PROPOSED FLOOR PLAN

422 FORE ST. SECOND FLOOR

EXISTING FLOOR PLAN  
422 FORE ST.  
SECOND FLOOR

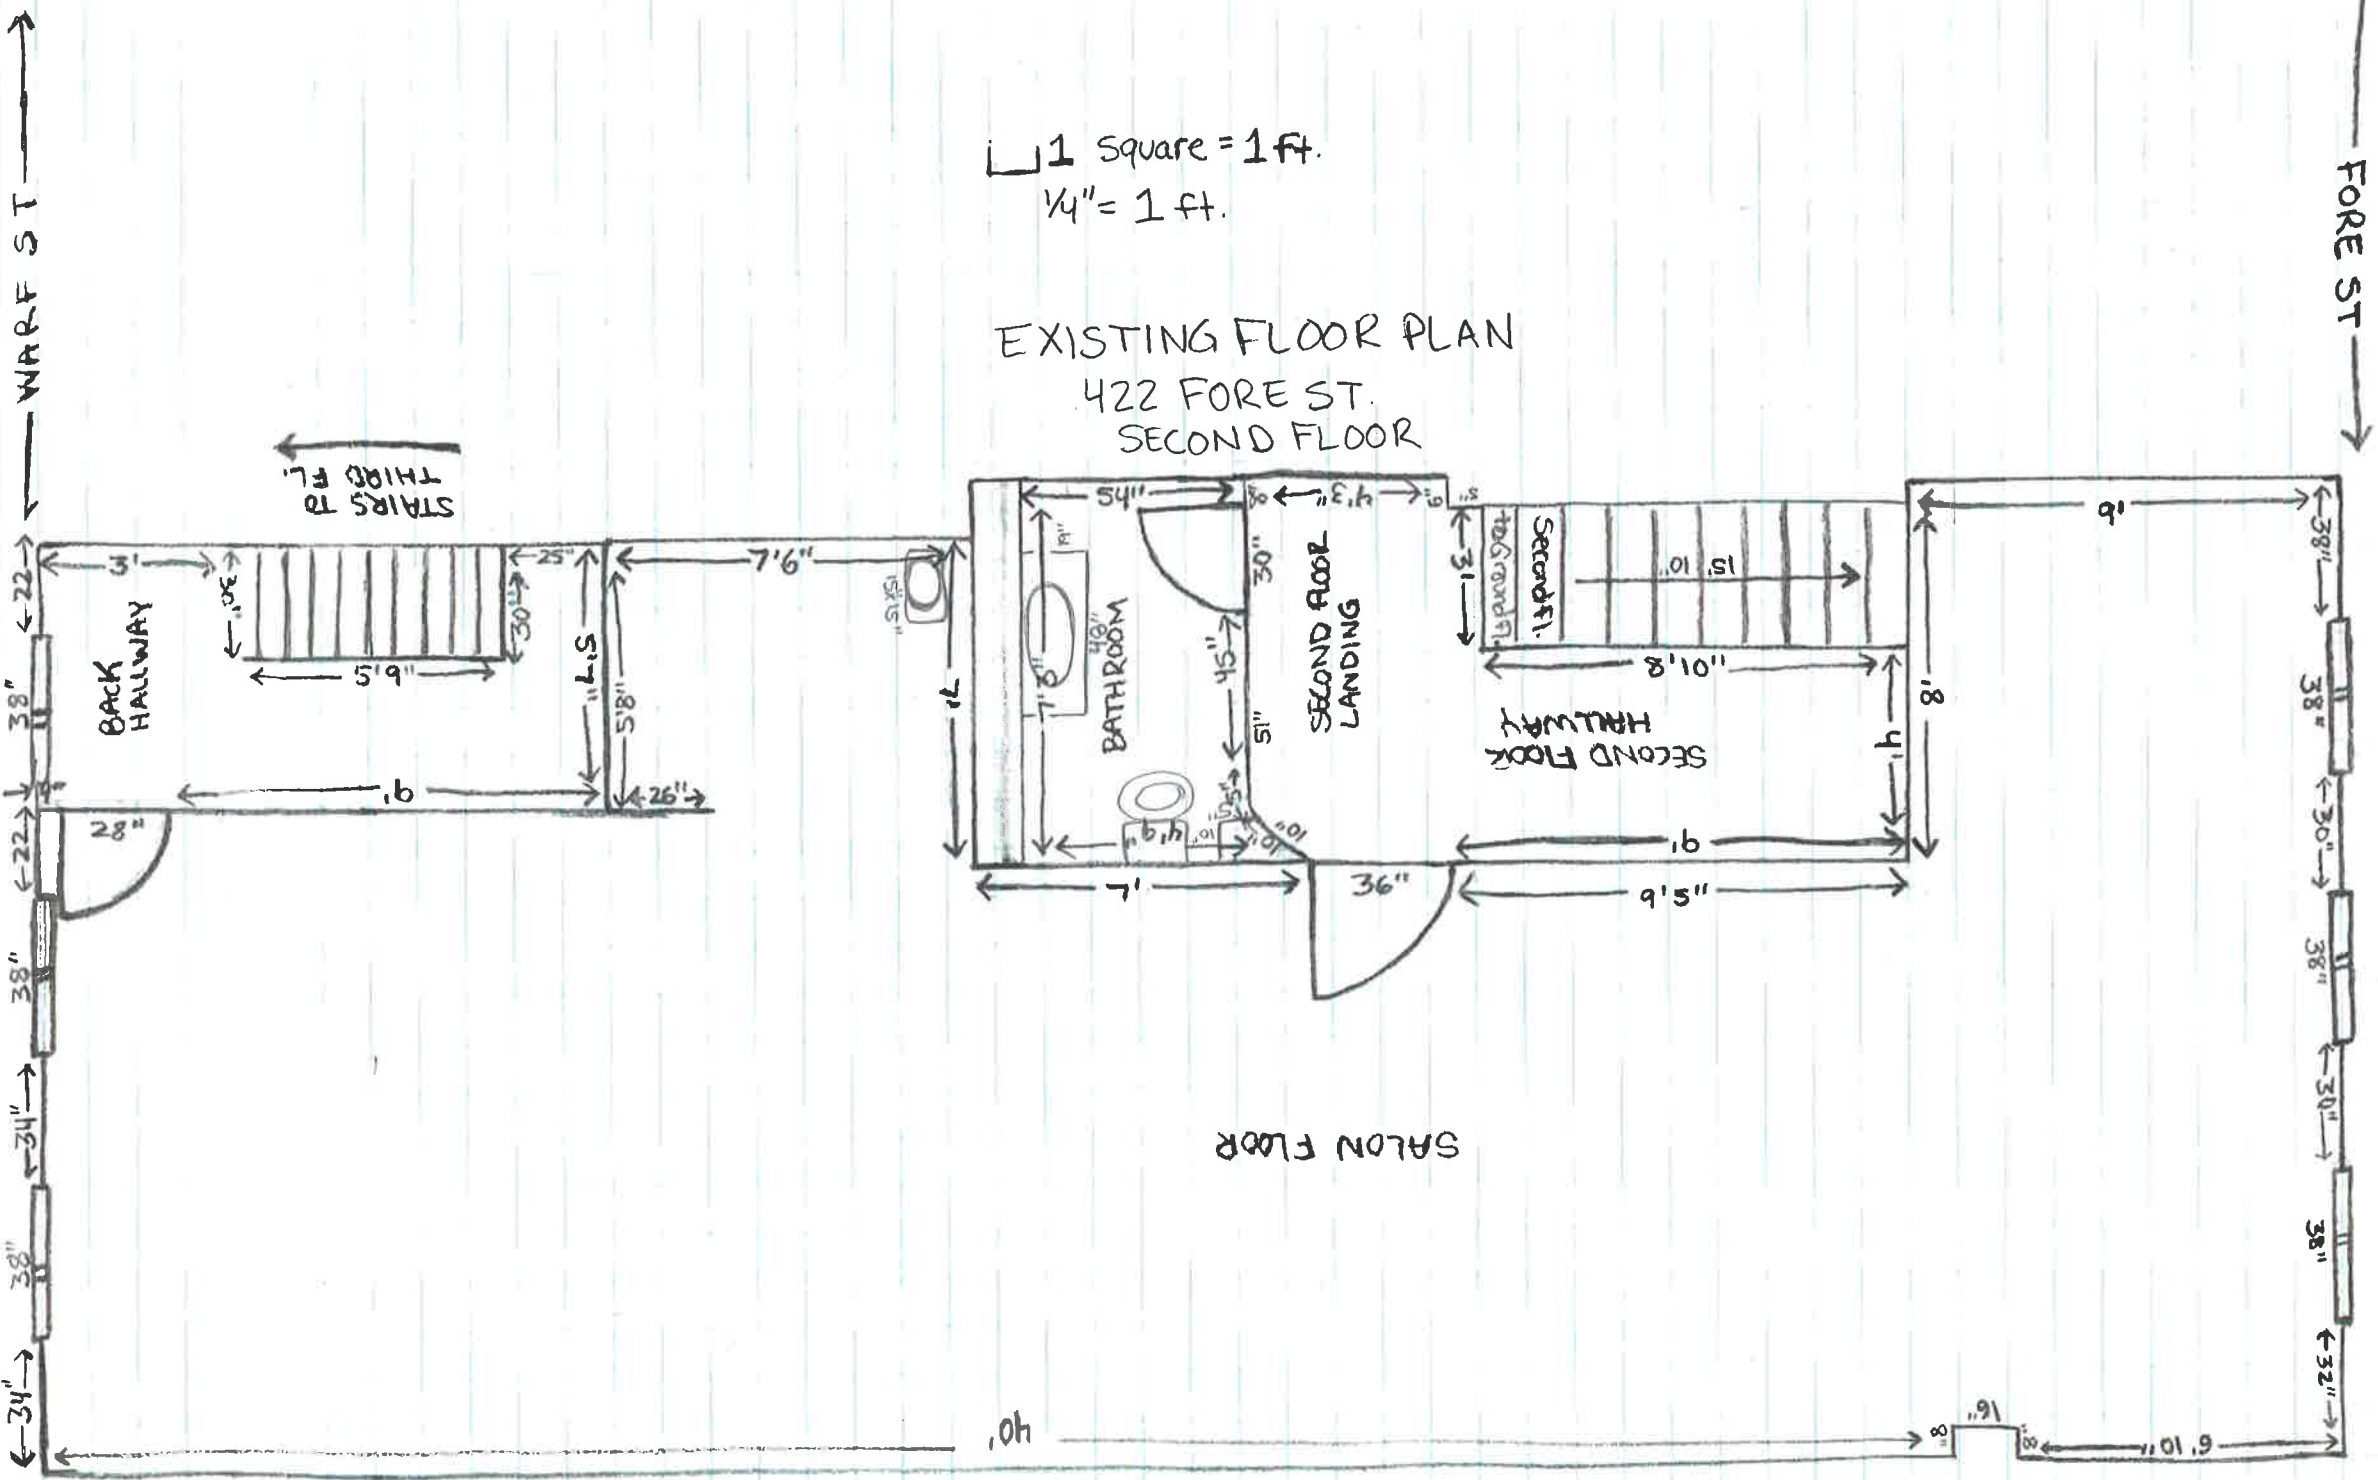
third floor is not part of tenants space
Is the third floor part of this tenant space?

Does this stair continue to an exit at grade?
this does not continue to grade

What do these represent?

What is this clear dimension?

Is the building sprinkled?
building is not sprinkled

This is a non- structural wall.
